**From:** [Nicole Davis](#)  
**To:** [Jack Turner](#)  
**Subject:** Heritage NSW - Advice on Amendment Report - Aboriginal Cultural Heritage (ACH) - Kurri Kurri Lateral Pipeline Project - (SSI-22338205) (Cessnock City, Maitland City, Newcastle City)  
**Date:** Monday, 17 October 2022 4:53:00 PM  
**Attachments:** [image001.png](#)  
[image002.png](#)  
**Importance:** High

Heritage NSW has reviewed the following documents with respect to Aboriginal cultural heritage (ACH):

- Kurri Kurri Lateral Pipeline Project - Aboriginal Cultural Heritage Assessment Addendum (Appendix C4) Final, Prepared by Umwelt (Australia) Pty Limited, on behalf of APA Group, September 2022.
- Kurri Kurri Lateral Pipeline Project - Submissions Report - Final - Prepared by Umwelt (Australia) Pty Limited, on behalf of APA Group, September 2022.

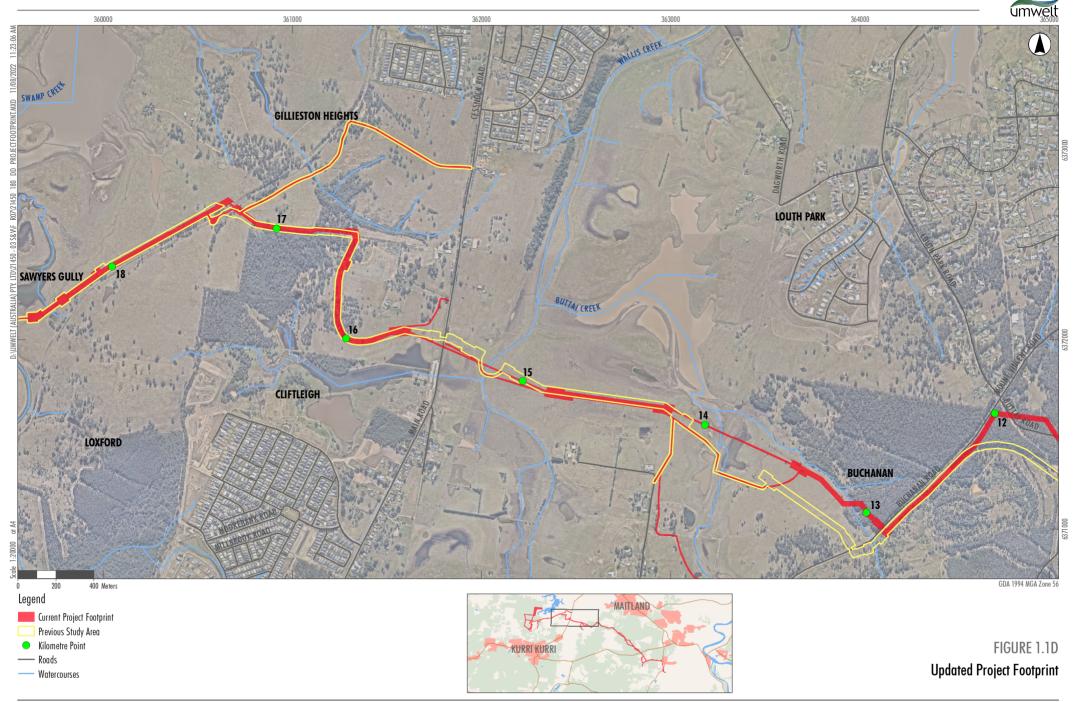
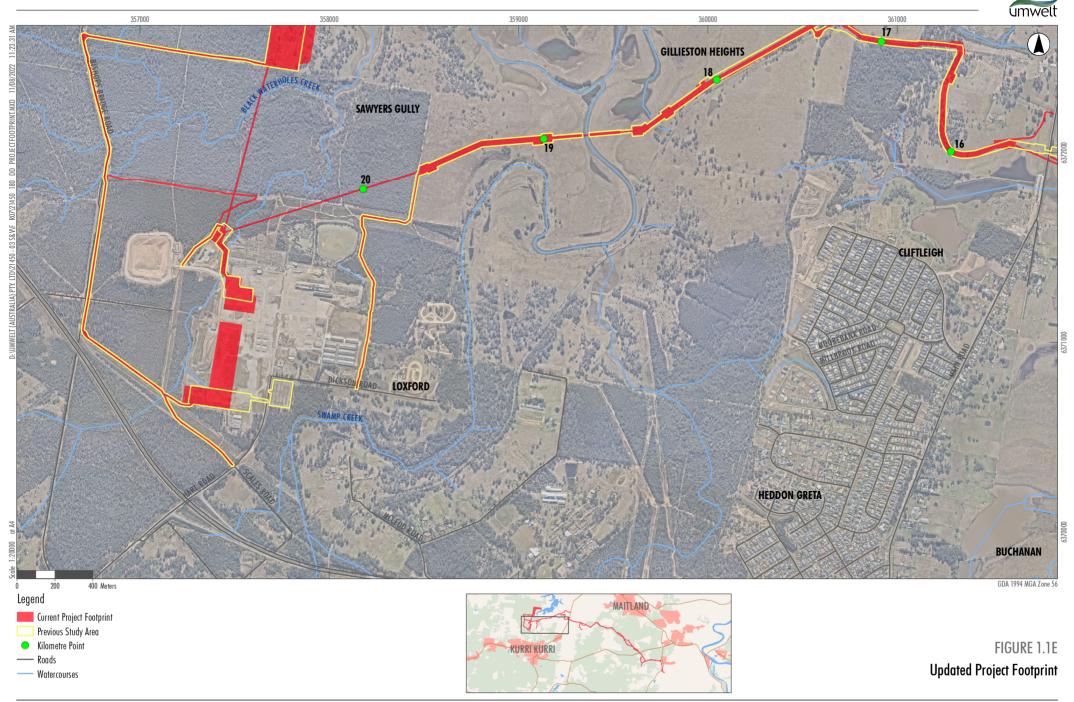
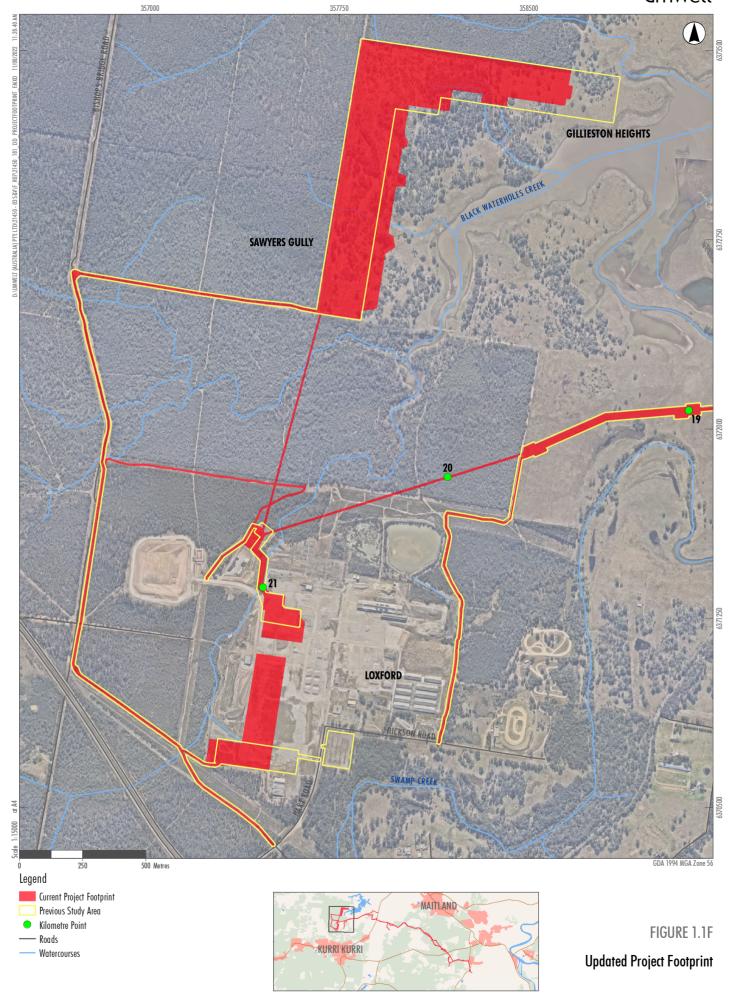
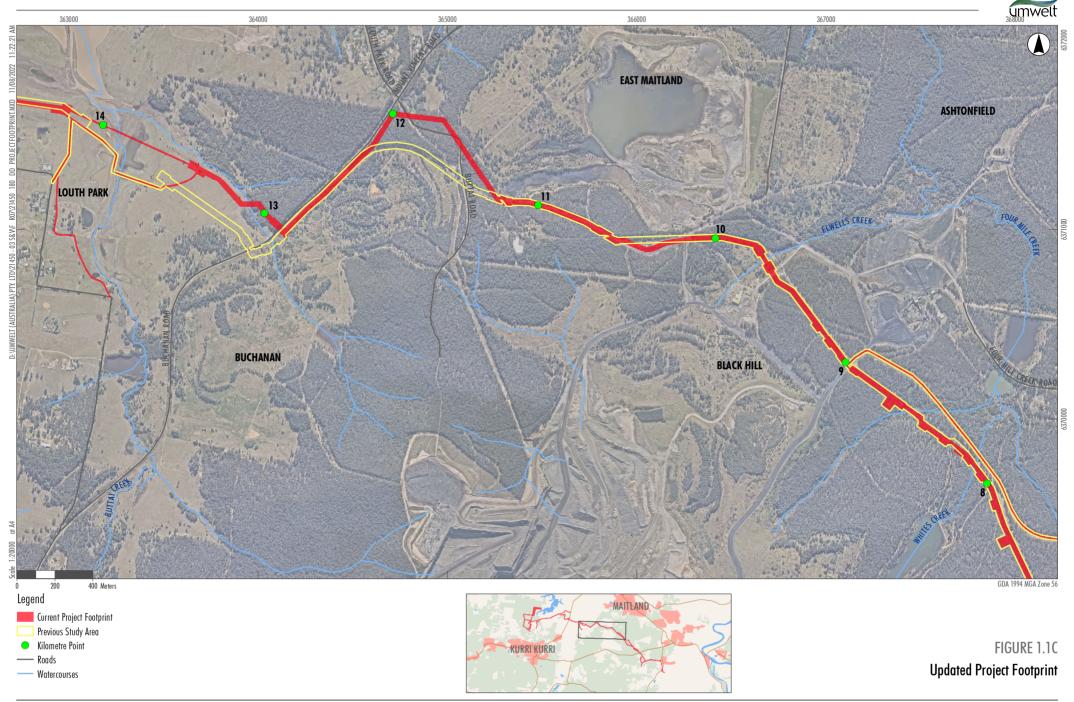
Heritage NSW requires the track logs and/or location of transects surveyed to assess the thoroughness of the archaeological survey. Please provided detailed mapping of the extent of survey units, landforms surveyed, and the areas within the units subject to survey. These maps should be presented at an appropriate scale to the survey unit.

I note that, an updated survey map, including survey tracklogs and survey unit details, is provided in the ACHA Addendum (refer to Figures 4.1A to 4.1F in Appendix C4 of the Amendment Report). It is noted that only the archaeologists participating in the survey were carrying GPS devices and the areas were surveyed, with the Registered Aboriginal parties spaced at appropriate intervals (as described in detail in the ACHA Addendum) to ensure adequate coverage.

- Heritage NSW is satisfied that Recommendation 1 has been appropriately resolved by the applicant.
